RE: ENGINEER CERTIFICATION FOR LOT 1 BLK.G CASHWAY SUBDIVISION
(F17-D70A) CERTIFICATION STATEMENT DATED 6/30/98

RE: REVISED DRAINAGE PLAN FOR LOT 1 BLOCK G CASILWAY SUBDIVISION
(F17-D70A) REVISION DATED 12/12/97

RE: DRAINAGE PLAN FOR LOT 1 BLOCK G CASHWAY SUBDIVISION (F17-D70A)
ENGINEER'S STAMP DATED 11/7/97

LOT 1 BLK G CASHWAY SUBDIVISION
GRADING AND DRAINAGE PLAN

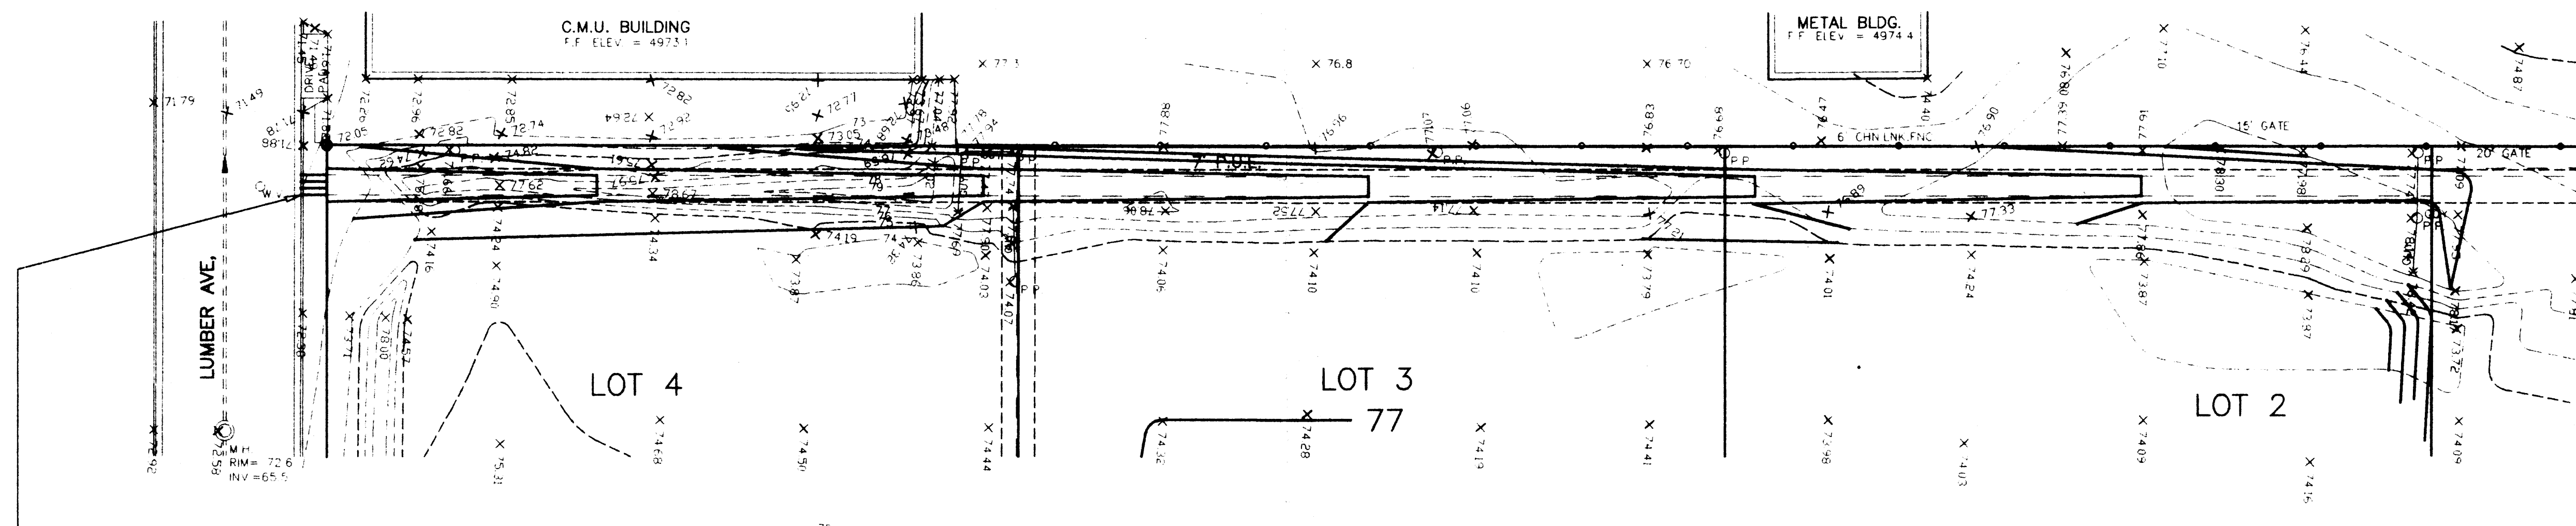
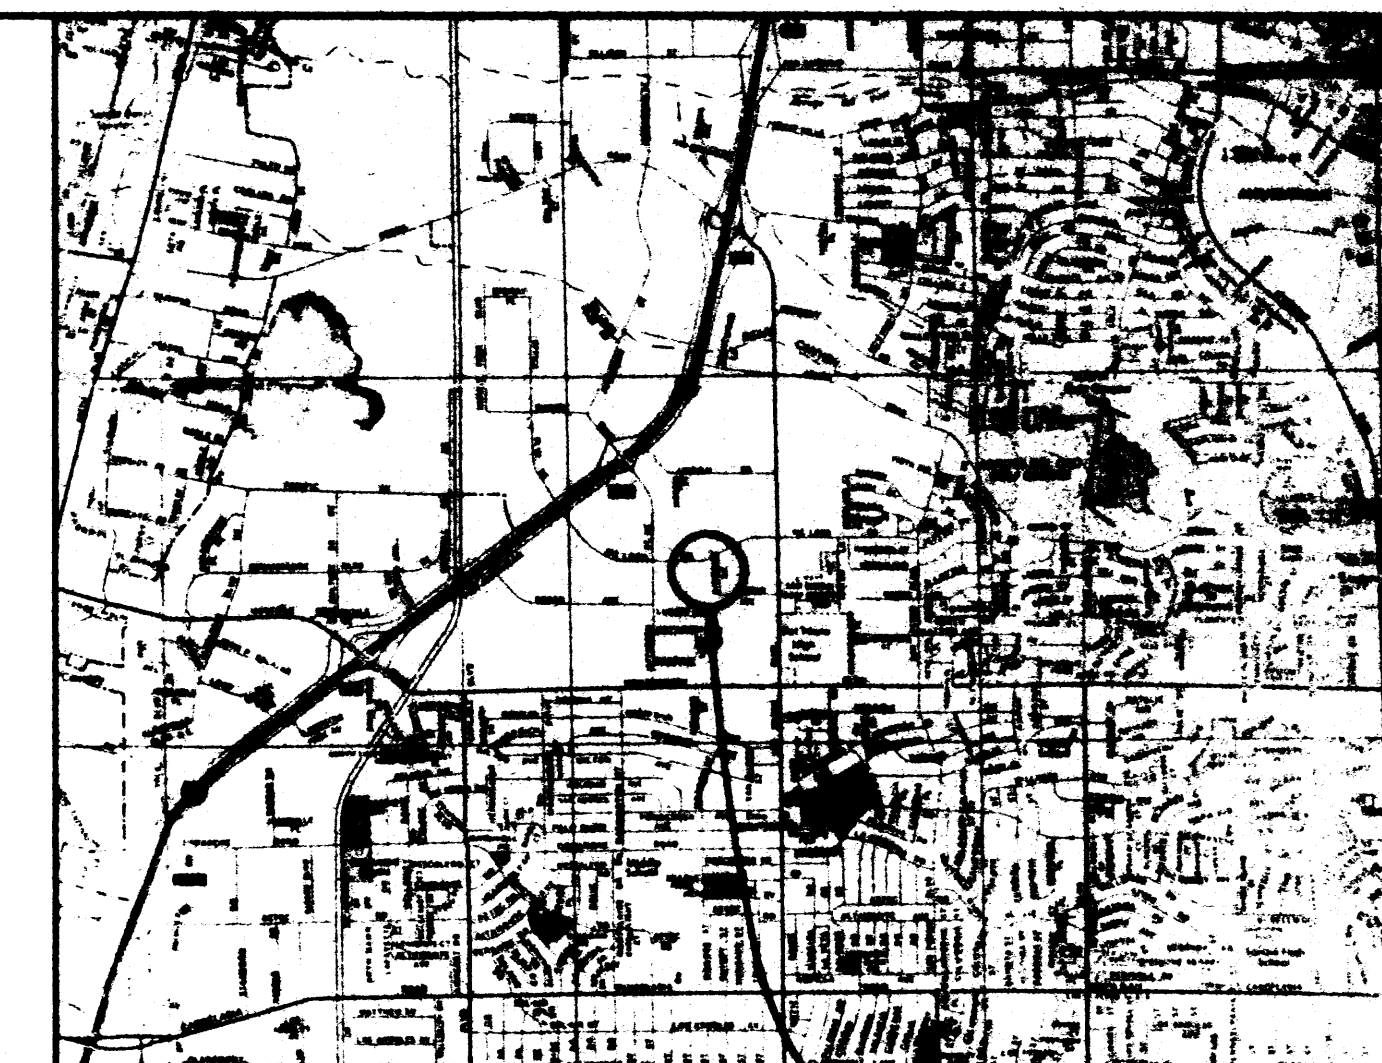
1. One foot water block is required at the property line along Hardware Dr. especially at the drivepad.
2. The proposed drainage swale within the 10' drainage easement will need to be designed as a permanent facility. Recommend that asphalt with a low-flow section be used.
3. Detail showing how the proposed swale will transition into the proposed side-walk culverts.
4. Indicate the Spec. No. On the plan drawing for the sidewalk culvert.
5. Two copies of the plan drawing with the resubmittal.
